April 24, 2020  
Merrick Project No. 65120399

**Re: Mountain View Academy - Site Development Plan;  
Grading and Erosion Control Plan (PPR-20-008)**

Merrick & Company has reviewed the comments dated March 17, 2020 regarding the Mountain View Academy Site Development Plan and Grading and Erosion Control Plan. The following summarizes Merrick's responses to the comments provided by the El Paso County.

Pond design will be reviewed on the resubmittal. Pond design may be altered significantly based on comments in the drainage report.

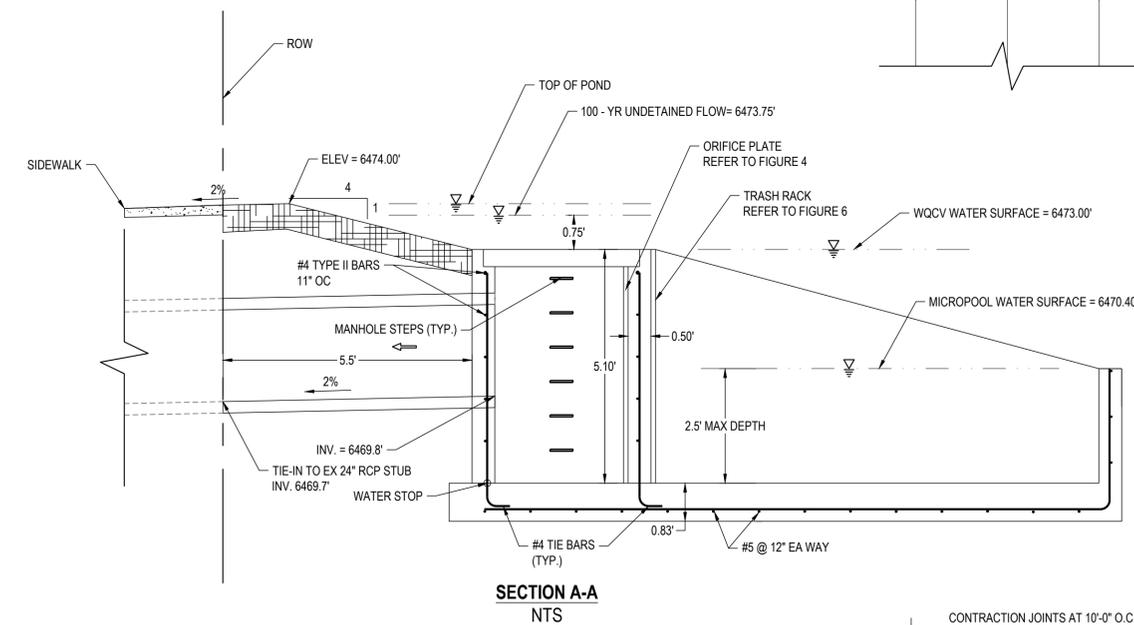
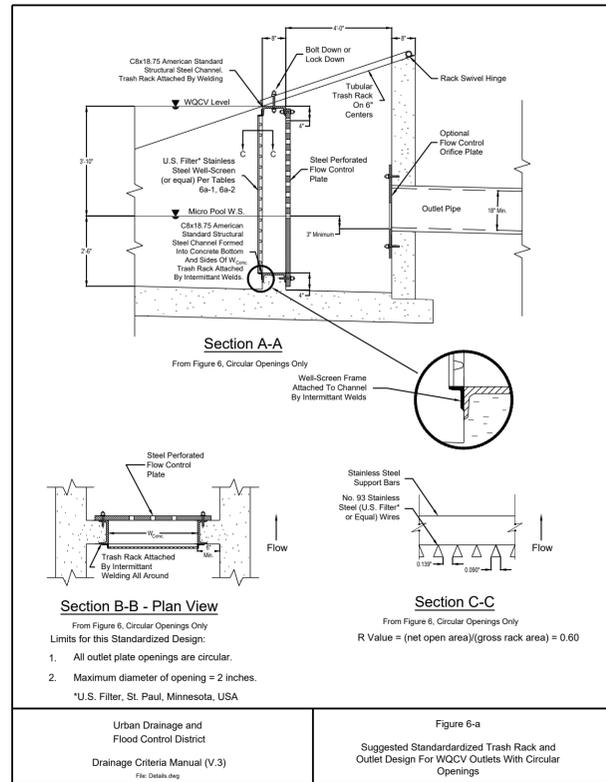
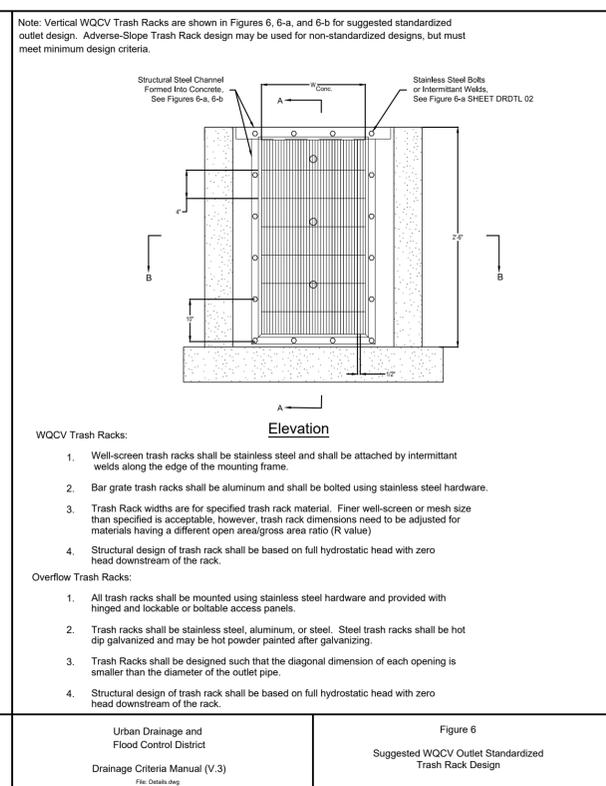
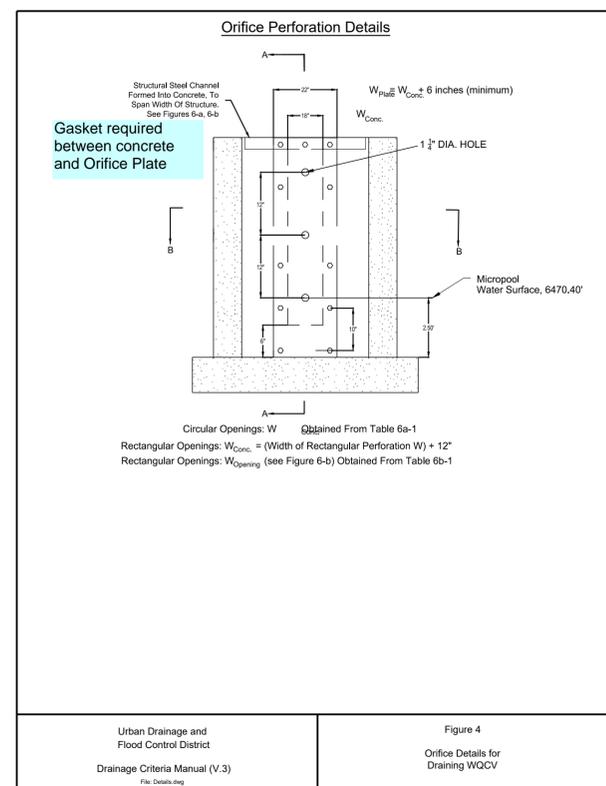
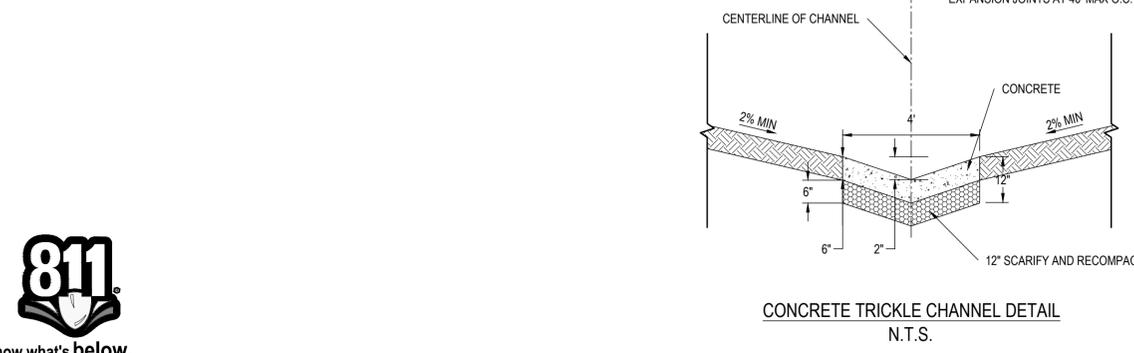
- Pond design will be reviewed on the resubmittal. Pond design may be altered significantly based on comments in the drainage report.  
[Response: Understood](#)
- Gasket required between concrete and Orifice Plate  
[Response: Understood](#)
